Monument Ridge East RS-6000 Zoning Map

NW1/4 Section 2, Township 11, Range 67 W 6th PM

Request: Request for
approval of a map
amendment (rezone) of 40.51
acres to the RM-12
(Residential Multi-Dwelling)
zoning district.

Monument Ridge East RM-12 Zoning Map

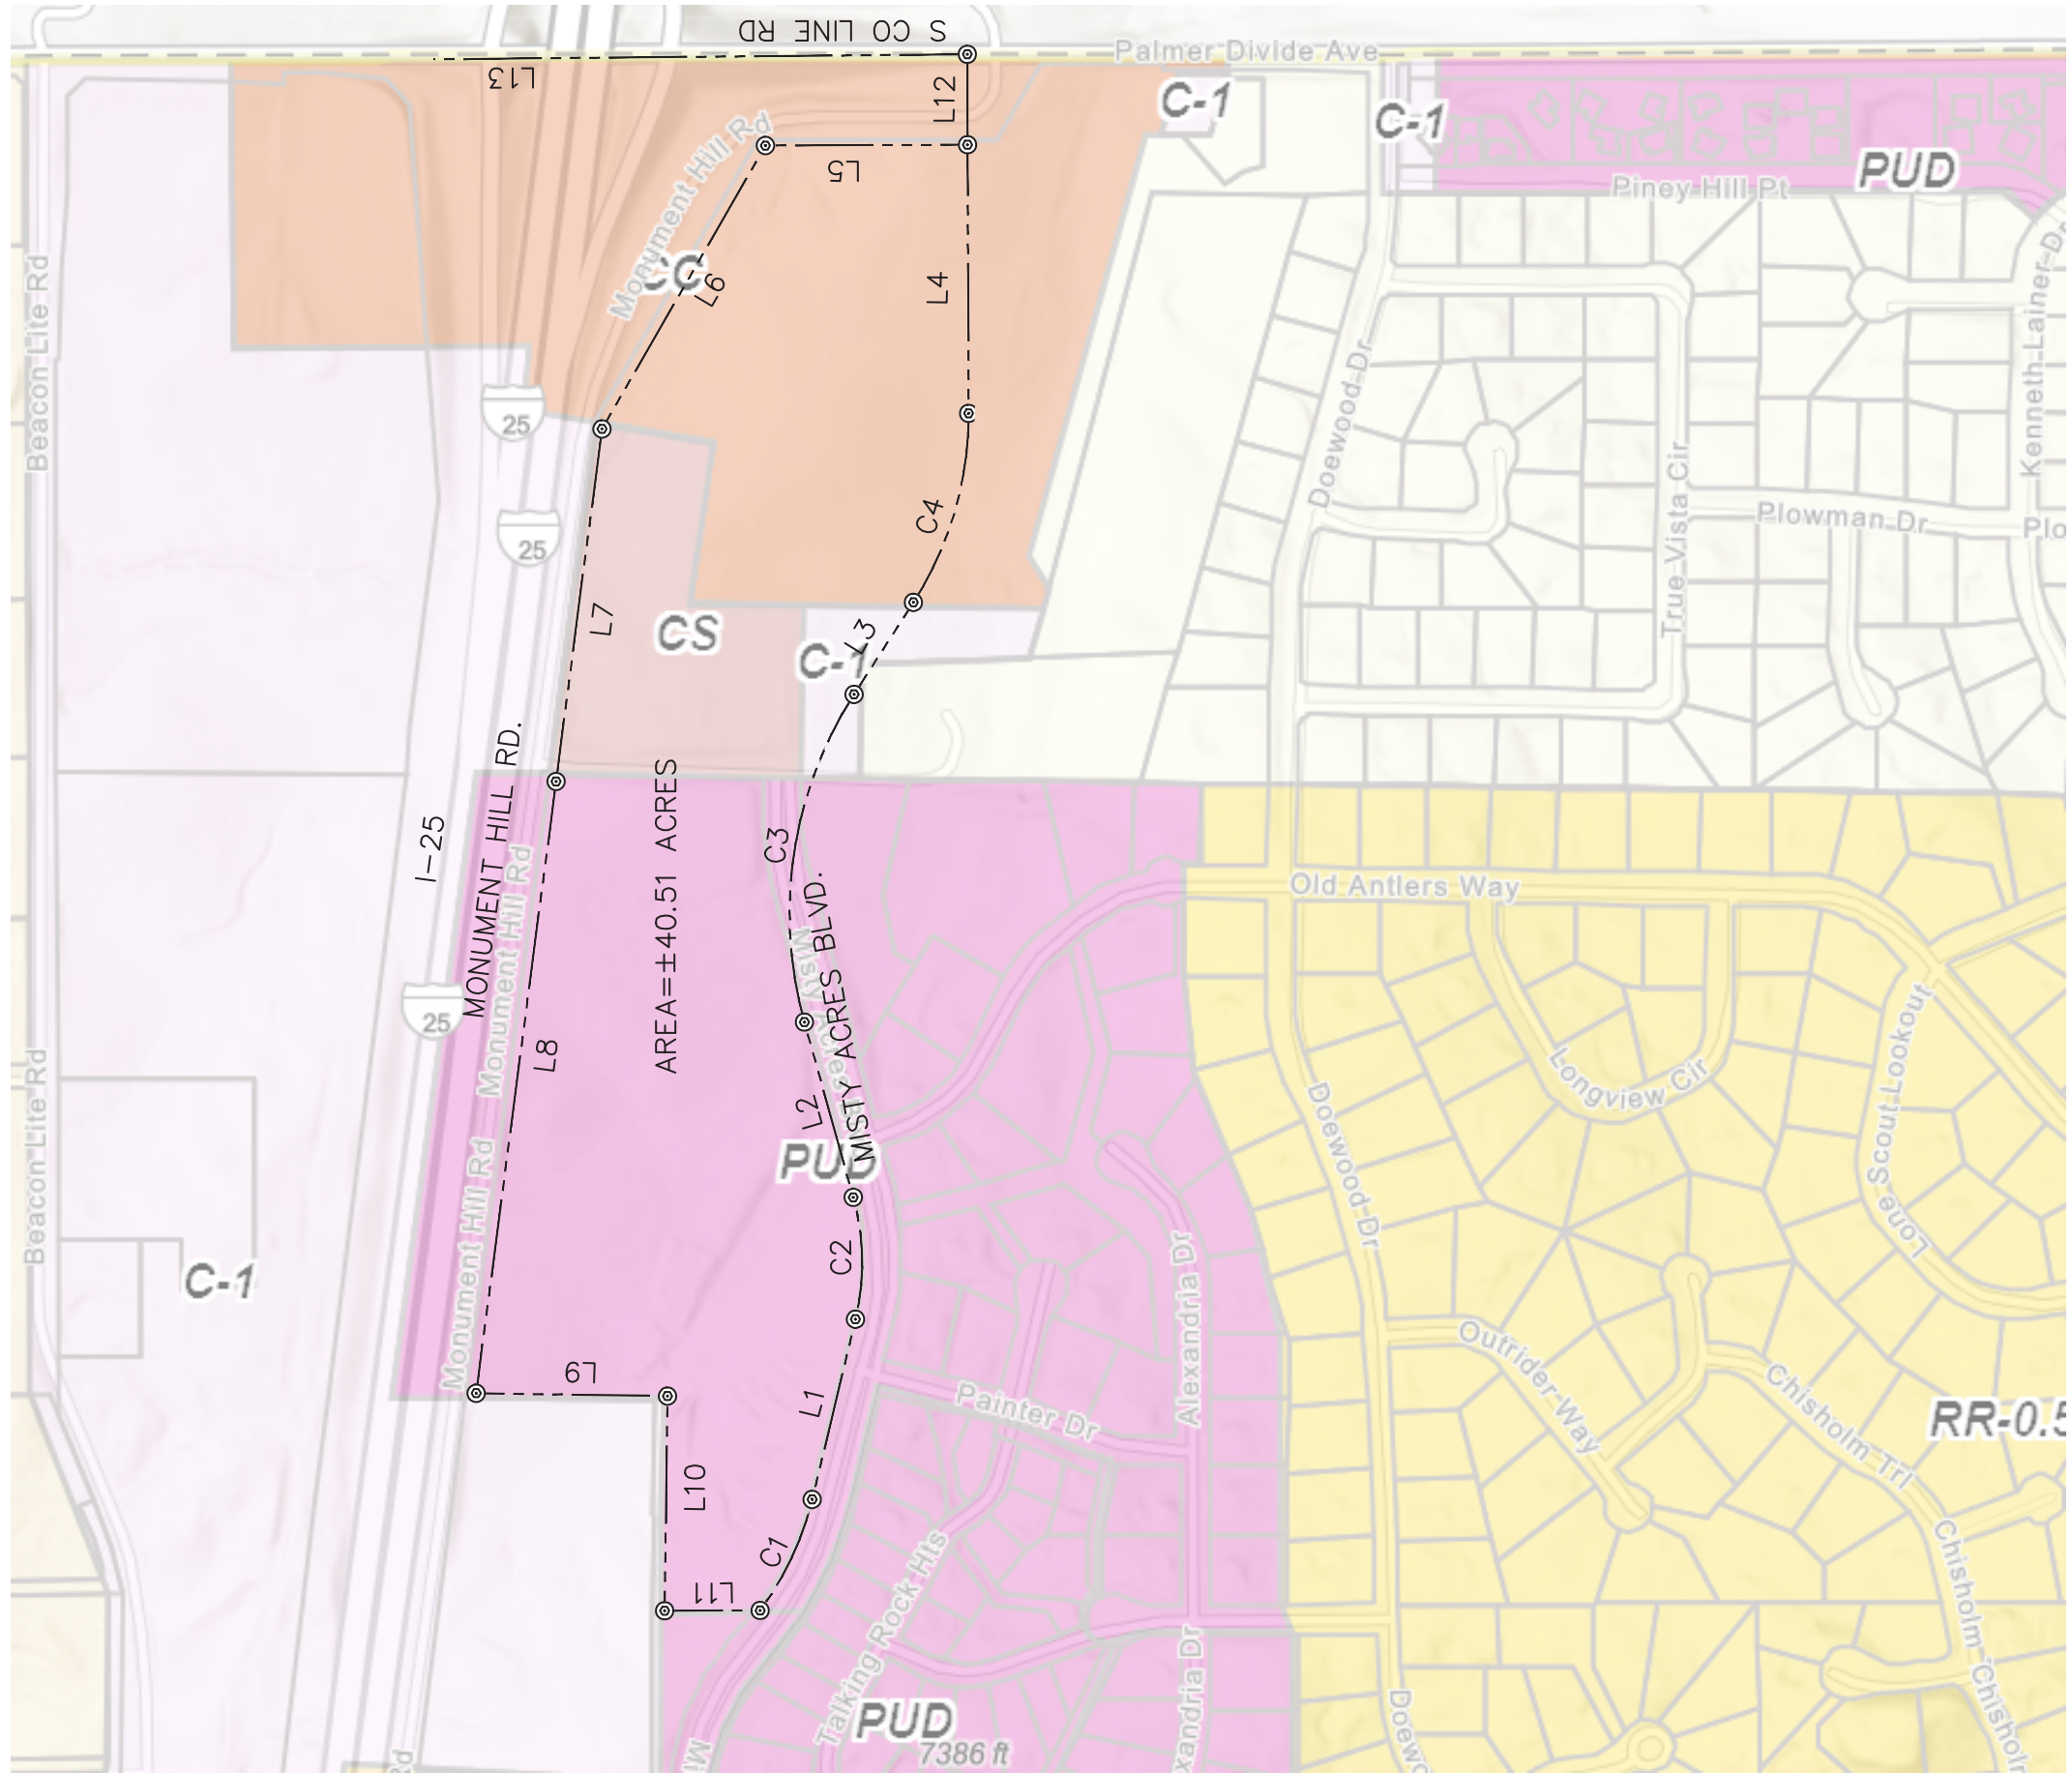
Remove zoning
colors

Please clearly label
boundary for each
zoning area.

Label is over
residential lots

The same map was provided with
the RM-12 proposal. Clearly depict
the RM-12 portion of the property.

Label is over two
roads. Clearly show
name of roads

Please include all
parcel Nos.

For each Zoning area,
please include:
proposed zone.

Scale is not correct.
When measure L1 I
get 538', the
surveyors line table
states it is 139'

Scale is not correct.
see my
measurements in red
vs. line table
